November 21, 2025

**Re: Target ABQ W at 5801 St Joseph's Drive NW
Erosion and Sediment Control Plan
Engineer's Stamp Date – 11/17/25 – G11E069F (SWQ-2025-00057)**

James D. Hughes, P.E., CPESC
Principal Engineer, Planning Dept.
Development and Review Services

SHEET NUMBER  
**C301**

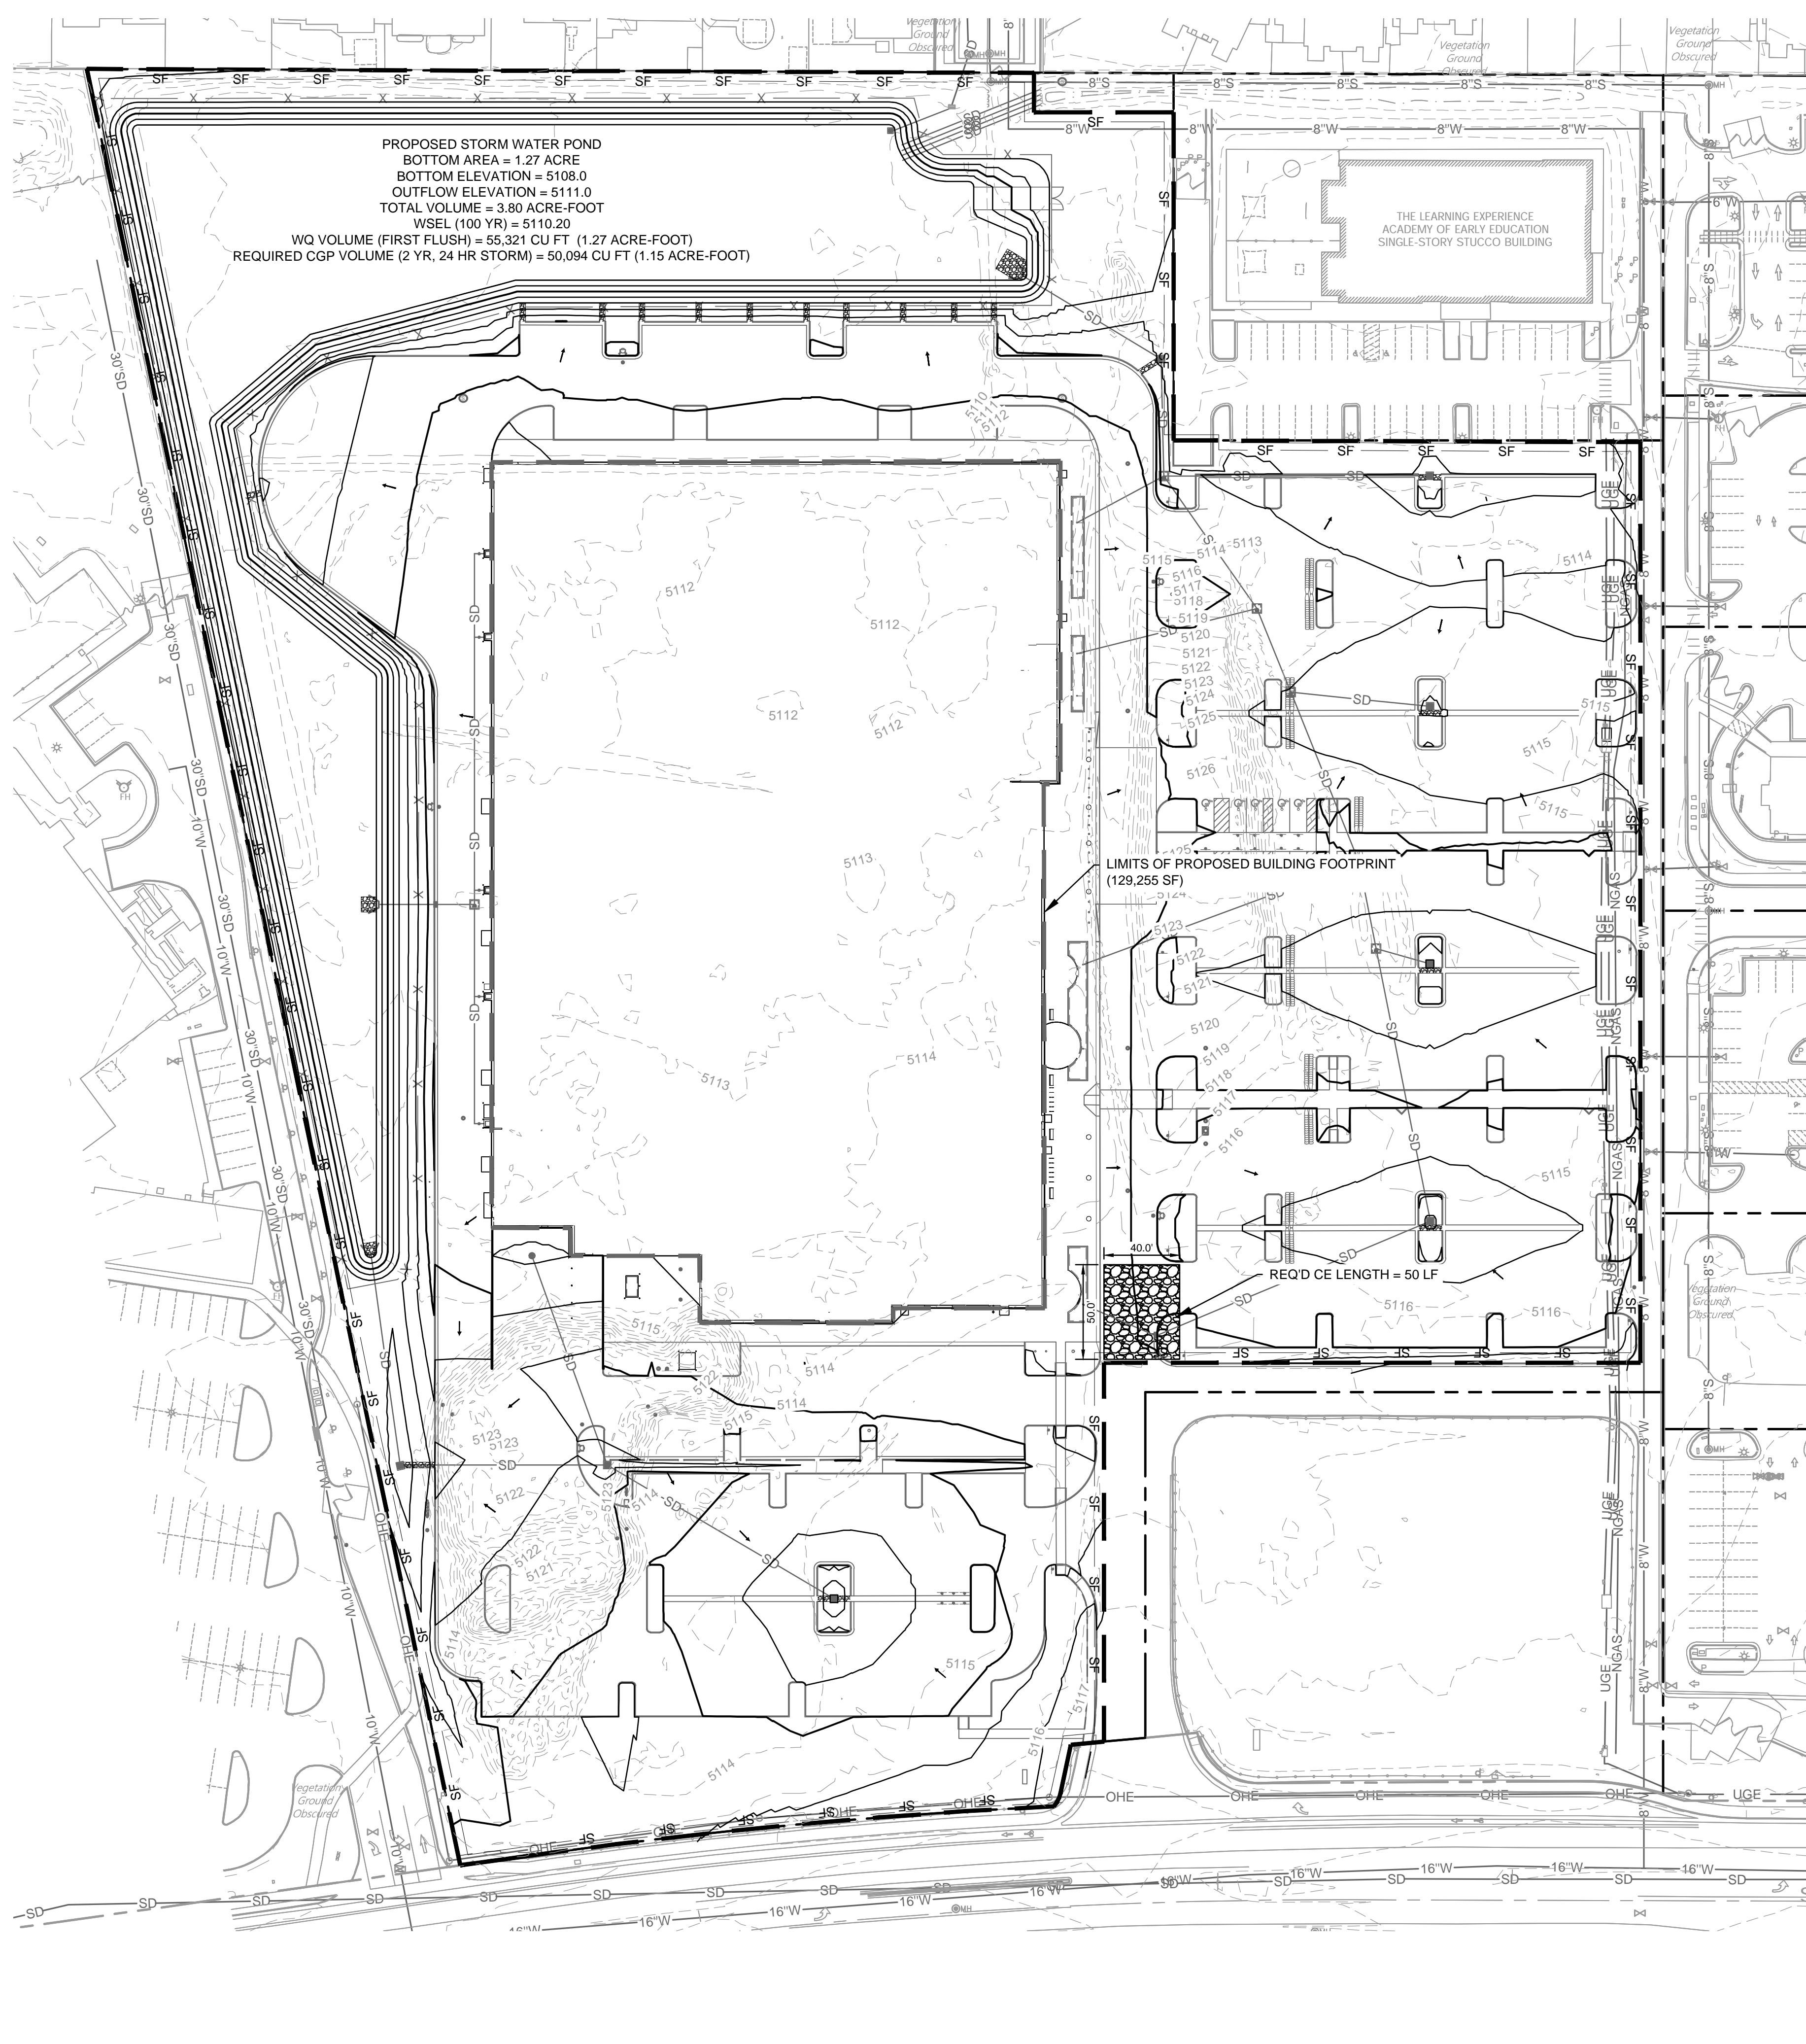
- 5. The Site Data and Albuquerque ESC Notes are not legible on sheet C300 & C301. The Albuquerque ESC Notes are out of date. Update the notes and ensure all text is legible.

2. Identify locations of concentrated flow paths that enter and exit the disturbed areas. Show on-site drainage patterns of stormwater before and after major grading activities. CGP 7.2.4.f.
